Reference No:	2026/62/91256/E
Site Address:	Meadow Court, 19, Northfield Lane, Highburton, Huddersfield, HD8 0QT
Description:	Demolition of single storey extension and raising of roof height to form first floor
Recommending Officer:	Joanna Rednall

DECISION – CONDITIONAL FULL PERMISSION

2026/91256

DRAWING TITLE  
**Site Plan**

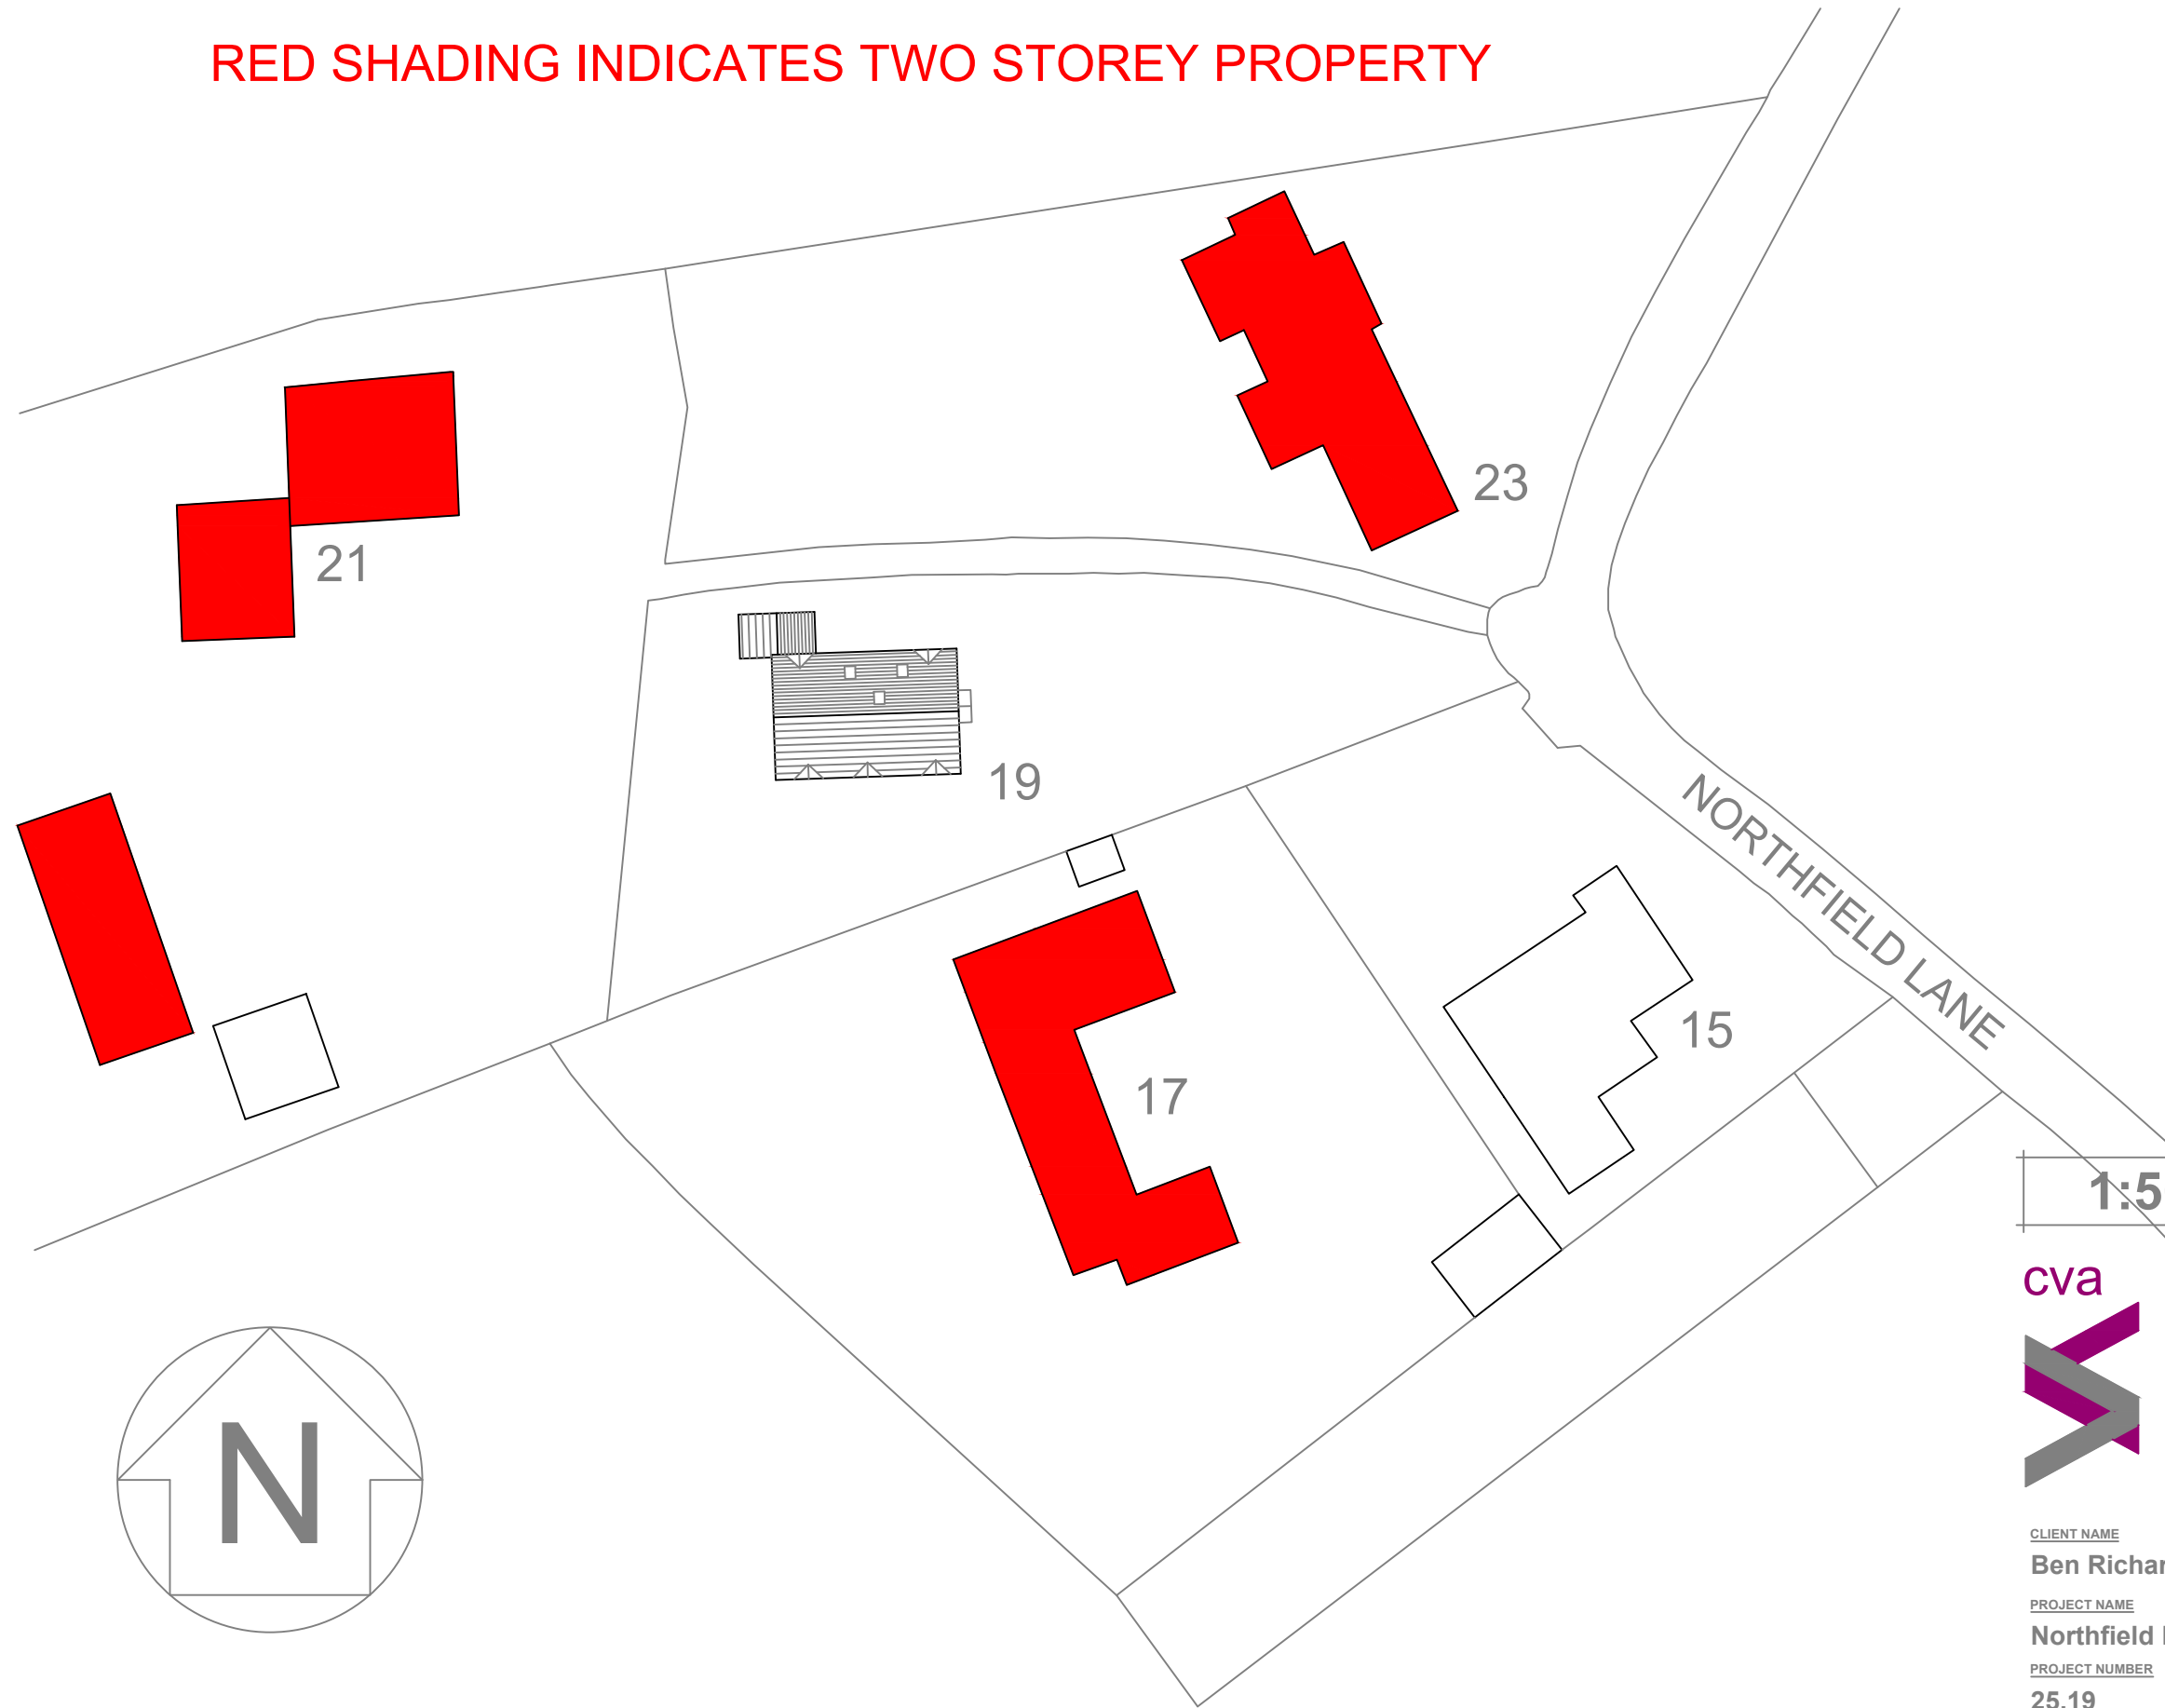
As set out above, the application site forms part of a small cluster of five dwellings which are loosely arranged, well-spaced, and varied in their orientation. The group displays no strong or consistent architectural character, with a mix of single-storey and two-storey properties. Of the five dwellings, three are two storeys in height and two are single-storey, including the application property. Consequently, the proposed increase in height would not appear incongruous or out of keeping with the established pattern of development. The use of gabled elevations and roof slope windows reduces the perceived bulk and massing of the enlarged roof, allowing the extension to remain proportionate to the host dwelling. Given the site's relatively isolated rural setting and the varied character of the surrounding built form, it is considered that the proposal would integrate satisfactorily within its context and would not result in harm to the character or appearance of the area.

The existing garage would be retained as part of the development, together with the full extent of the existing front driveway, which measures approximately 35 metres in length. In addition, there is an area of hardstanding to the side of the dwelling capable of accommodating a further vehicle. Whilst the submitted plans do not include a formal parking layout, officers consider that from the scale and configuration of the existing hardstanding that the site is capable of accommodating at least three vehicles within its curtilage without resulting in a reliance on on-street parking.

Proposed Plans

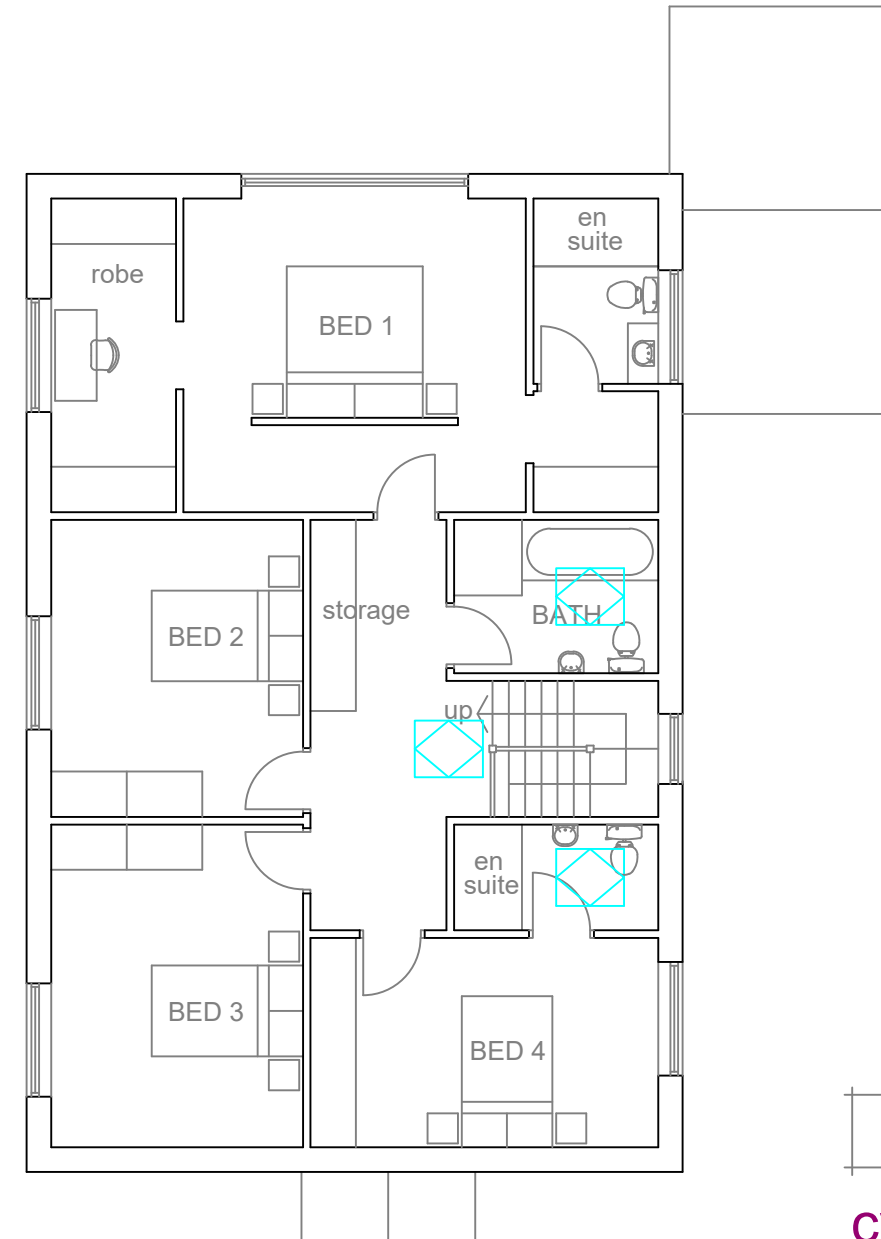
The development serves four bedrooms, three bathrooms, and a wardrobe room. The proposed works would increase the number of bedrooms within the dwelling from two to four.

The proposal would increase the size of the dwelling from two to four bedrooms. In accordance with the Council's Extensions SPD, a dwelling of four or more bedrooms is expected to provide a minimum of three off-street parking spaces.

Existing & Proposed Elevations

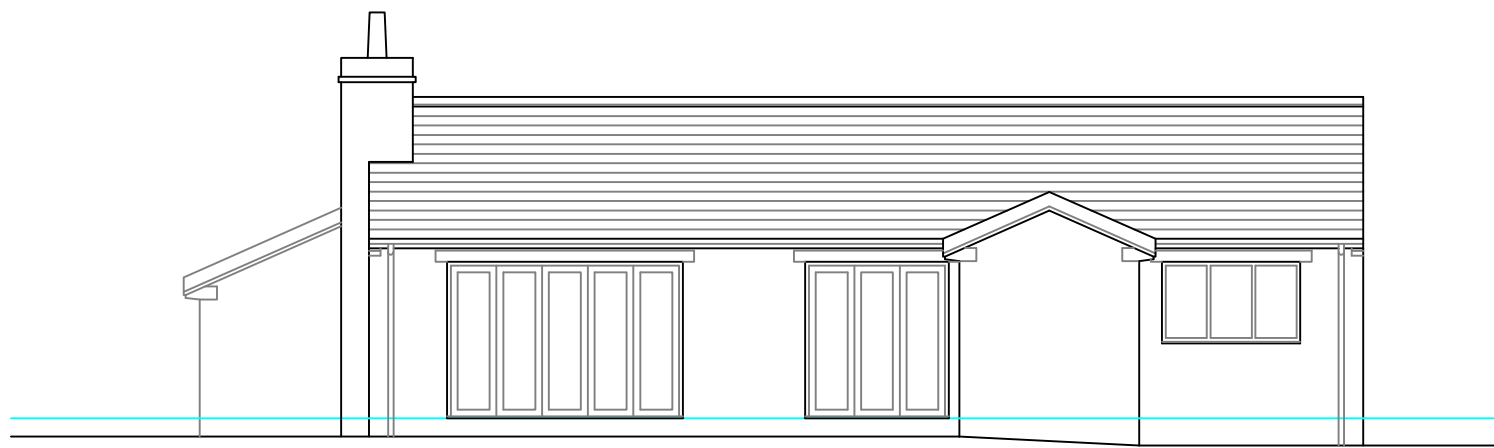
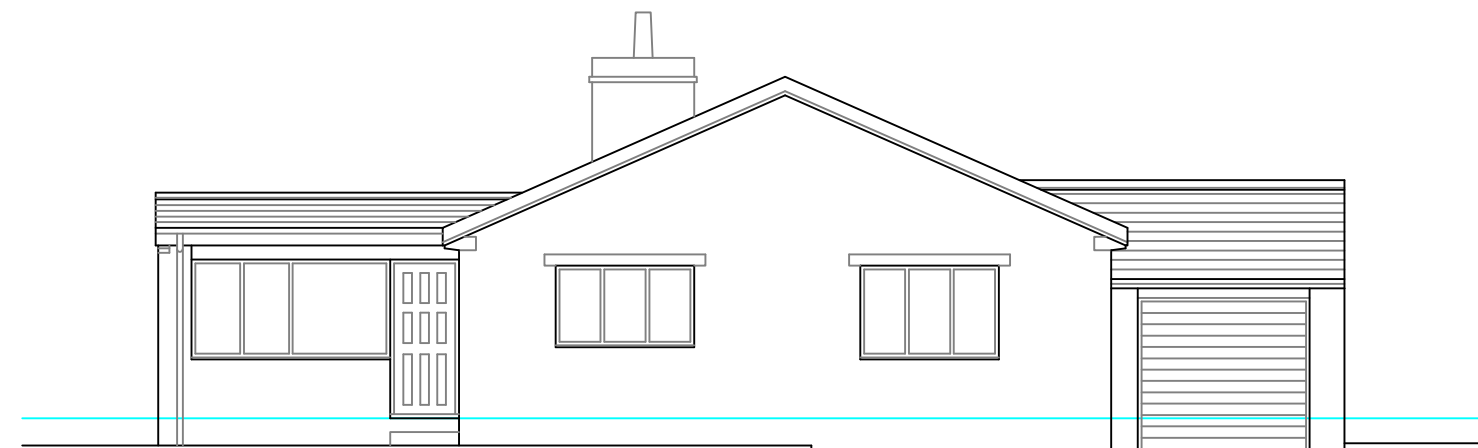
The proposed extension would increase the overall height of the dwelling to approximately 4.5 metres at the eaves and 6.5 metres at the ridge. The extension would follow the existing ground floor footprint and would be finished in render, with a pitched roof covered in concrete tiles to match the existing dwelling.

The development would result in a 1.5-storey appearance, incorporating three gable windows within the south elevation and two gable windows within the north elevation. Three rooflights and a tall window are proposed within the north roof slope, with a larger area of glazing proposed to the west-facing gable elevation.

The proposal also includes alterations to the existing fenestration at ground-floor level. An enlarged opening is proposed within the west-facing elevation, together with the reconfiguration of windows on the north-facing elevation. The existing openings within the east and south elevations would remain largely unchanged, albeit with minor reductions in size.

In volumetric terms, the proposed increase is not considered excessive, particularly when having regard to the demolition of the existing single-storey extension. Visually, whilst the ridge height would increase from approximately 4.8 metres to 6.5 metres, the proposal has been designed to minimise the perception of additional bulk. The enlarged roof form incorporates gabled elevations and roof slope fenestration, reducing the apparent scale and ensuring the building retains a domestic character. Furthermore, the extension would largely follow the footprint of the existing dwelling, with no significant lateral spread or encroachment across the site. When viewed as a whole, the original dwelling would remain readily identifiable and visually dominant, and the proposal would read as a proportionate enlargement.

With regard to design, the proposed external materials comprise a rendered finish with reclaimed roof tiles from the existing dwelling. Although render differs from the existing stonework, the dwelling occupies a within a dispersed cluster of development characterised by varied architectural styles, forms and external finishes. In this context, the proposed material palette is not considered to appear incongruous. Furthermore, the lighter render finish would assist in visually softening the enlarged form of the building within the landscape. To ensure a satisfactory appearance, a condition is recommended securing the render colour, which shall be an off-white, cream or natural stone finish.

With regard to privacy, the proposal includes first-floor windows within the west-facing gable elevation, serving a bedroom. These windows would face towards the side elevation, driveway and part of the garden area of No. 21, where two existing first-floor windows also face towards the application site. The separation distance between the proposed first-floor window and the side elevation of No. 21 would be approximately 25 metres, exceeding the minimum 21-metre separation distance between opposing habitable room windows recommended within the Council's Extensions SPD.

With regard to privacy, the proposal includes three additional first-floor openings within the elevation facing No. 17, comprising two bedroom windows and one window serving a wardrobe/dressing room. The application site occupies a slightly lower ground level than No. 17, and the proposed windows would principally overlook the rear garden rather than directly towards the neighbouring dwelling. Furthermore, the existing mature boundary vegetation, including established hedging and trees, provides substantial screening between the two properties. The windows are also positioned within the gabled roof form, resulting in lower window heights than would typically be associated with a full first-floor elevation. Consequently, opportunities for direct overlooking would be limited. Taking these factors together, it is not considered that the proposal would result in an unacceptable loss of privacy or otherwise have a detrimental impact on the living conditions of the occupiers of No. 17.

With regard to privacy, the proposal includes three first-floor windows within the north-facing elevation serving a bathroom, staircase and bedroom. These windows would be positioned approximately 7.5 metres from the shared boundary and approximately 26 metres from the rear elevation of No. 23, thereby exceeding the 21-metre separation distance between opposing habitable room windows recommended within the Council's Extensions SPD. The proposed windows are set well back from the neighbouring dwelling, and the existing driveway together with established boundary planting provides additional separation and screening. Taking these factors into account, it is not considered that the proposal would result in an unacceptable loss of privacy or otherwise harm the living conditions of the occupiers of No. 23.

3. The external render walls of the first-floor extension hereby approved shall be of an off-white, stone or cream through render material and colour finish. The materials of construction and colour finishes approved by this condition shall be completed prior to the development being brought into use and thereafter retained for the lifetime of the development.
